Engineers Comments Regarding Surface Water Drainage

Application Reference:	WA/109/24/OUT	Reviewer Reference:	ADC/PC
Planning Officer:	Hannah Kersley	Date of Review:	27/08/2025
Site Name:	Sussex Business Village Lake Lane Barnham PO22 0AL		
Application Description:	Outline planning permission for 3 No. attached dwellings with associated gardens, access and parking. This application is in CIL zone 3 (CIL liable as new dwellings) and is a dual parish application with Yapton Parish Council.		
Assessment Number:	1 of 1

Response Objection

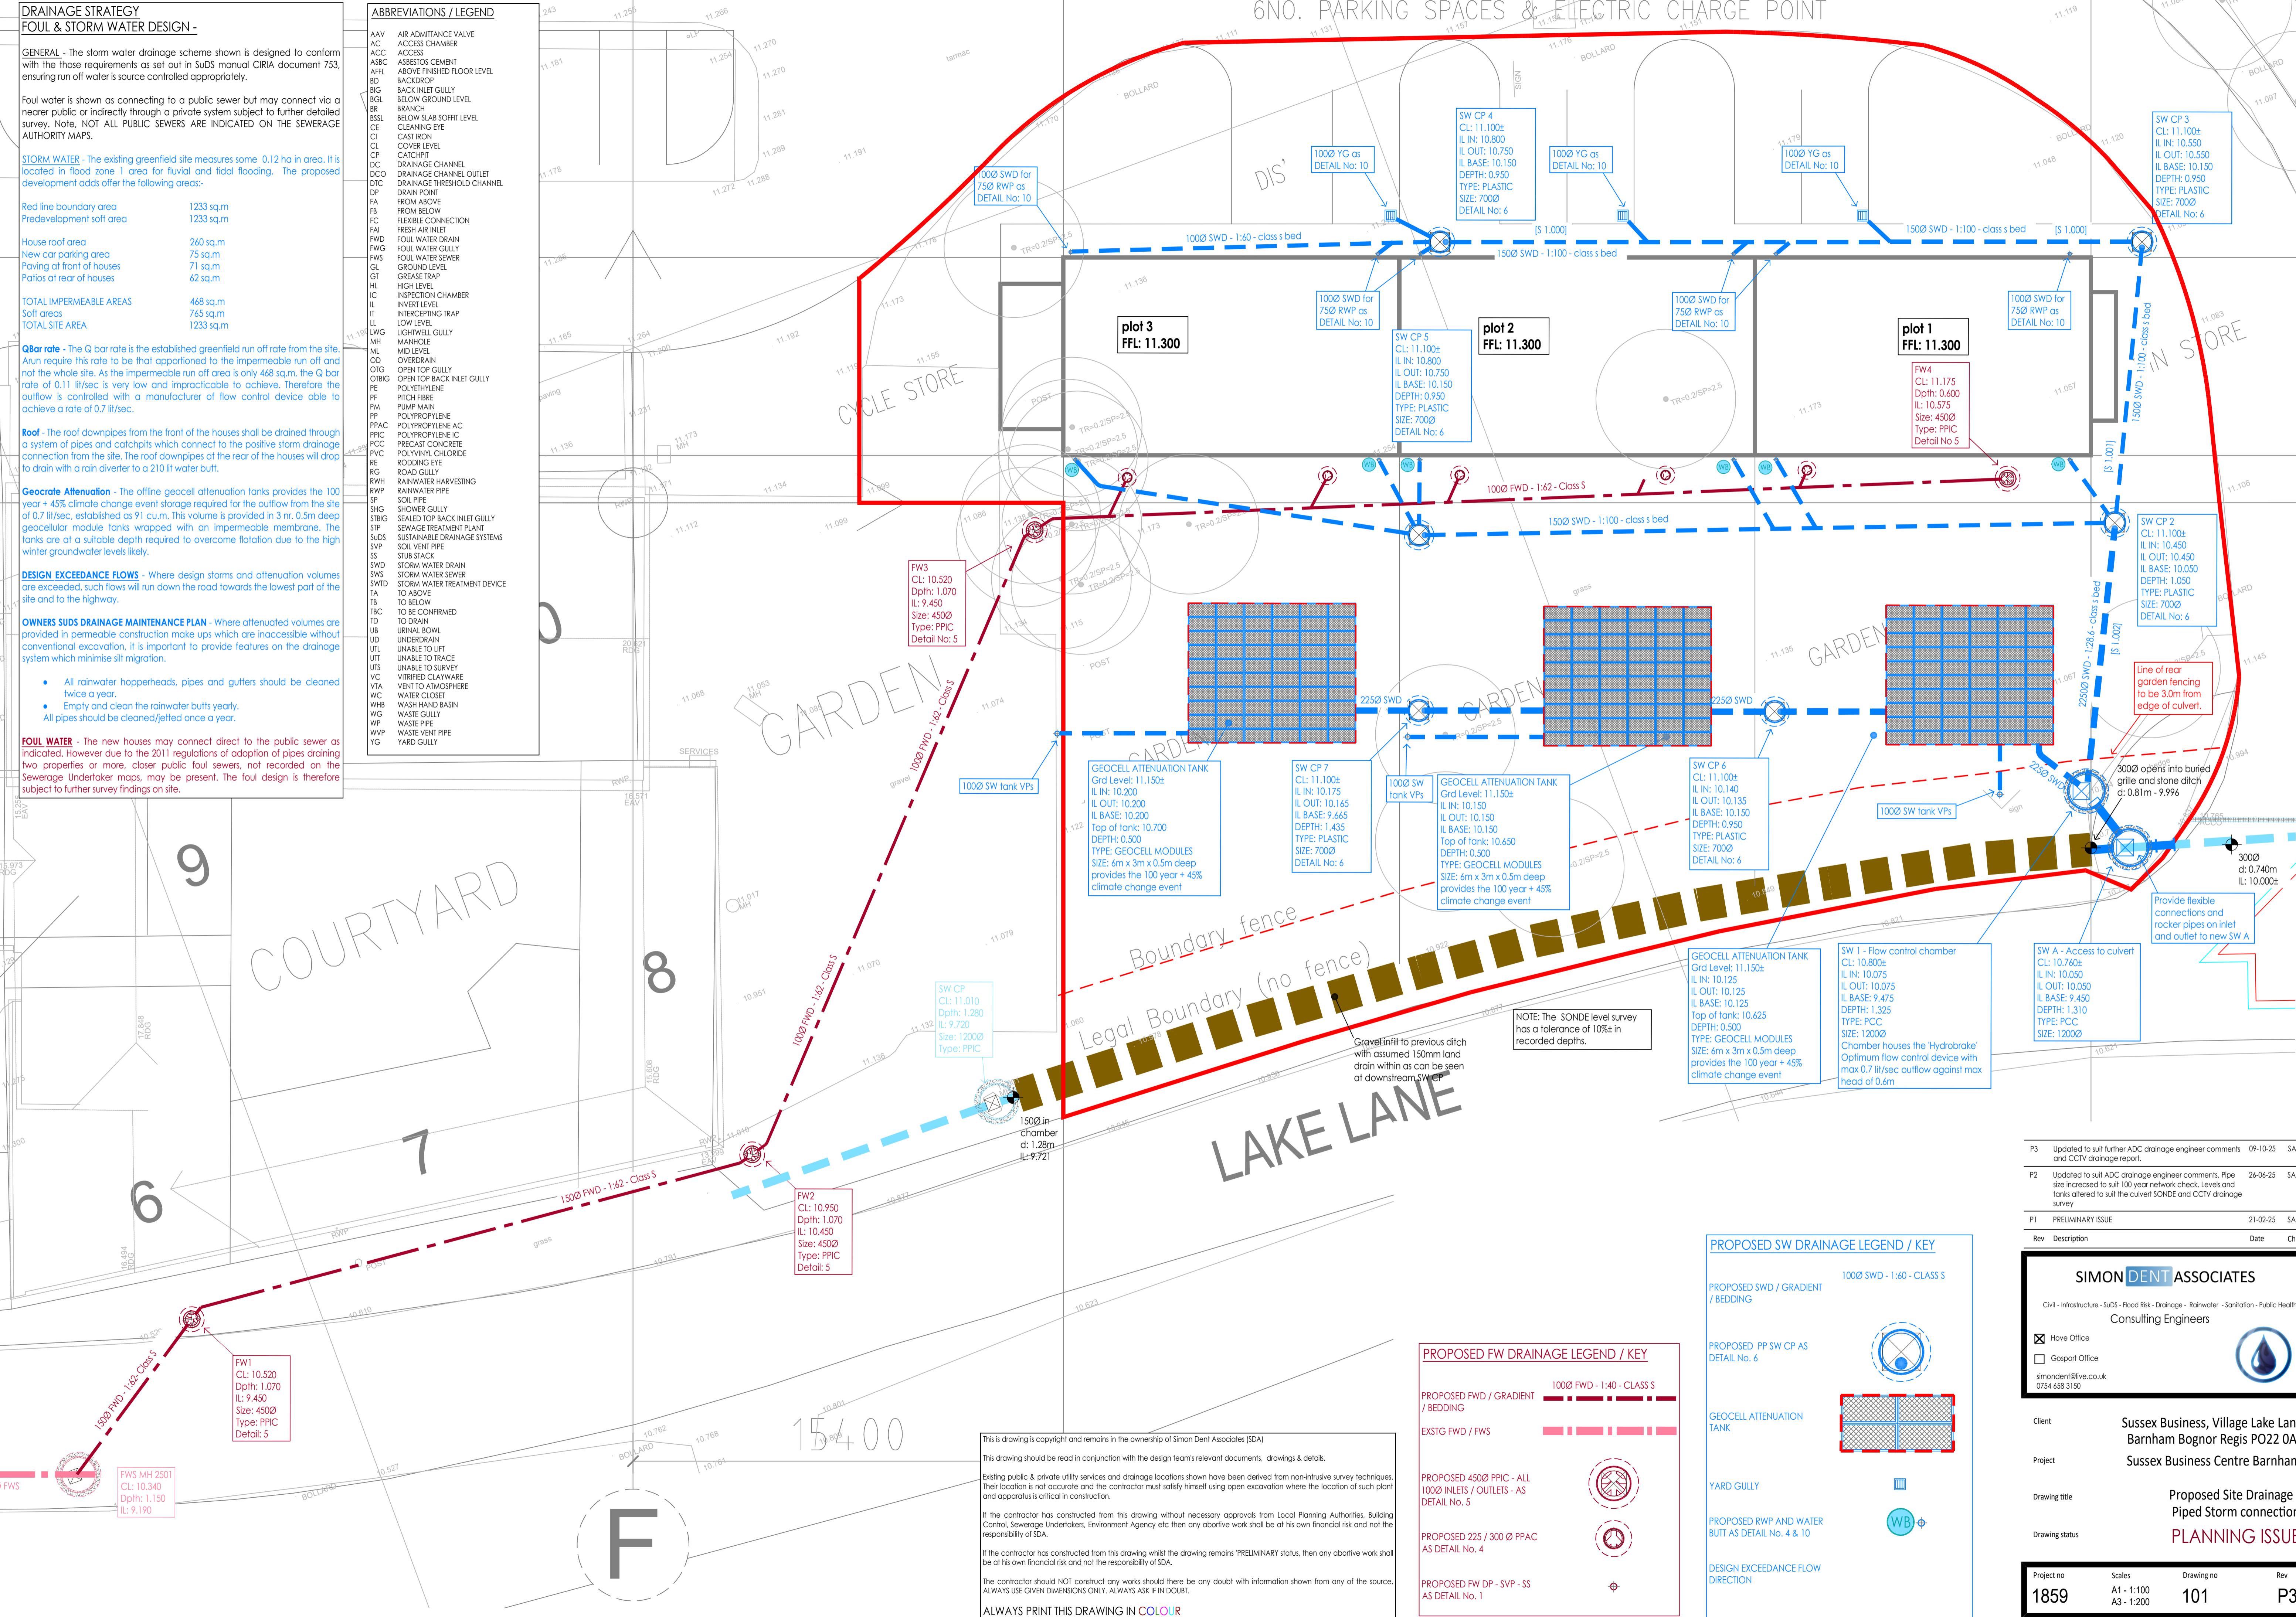
In terms of the proposed connection level to the culvert, it is unclear as to whether a soffit to soffit connection is being achieved. The short length of 100mm diameter pipe downstream of flow control chamber SW 1 requires a positive gradient (currently laid flat). The existing culvert is shown as 225mm diameter on the plan but the CCTV survey indicates it as 300mm diameter. Which is correct needs to be verified and the plan adjusted if necessary. The specified overall depth of manhole SW 1 is incorrect (should be 1.3 metres as opposed to 2 metres) and should be corrected. Based upon the estimated culvert invert level of 10.000

downstream of the proposed connection , it appears that a soffit to soffit connection is not being achieved. It will need to be clearly demonstrated that it is possible. The applicant may wish to consider utilising a pipe diameter equal to the culvert diameter, for the short length of pipe downstream of chamber SW 1 to help achieve the requirement.

2. A revised plan showing that a minimum 3 metres distance is achieved between the edge of the existing culvert and any structure/boundary fencing. This currently measures less than 3 metres.
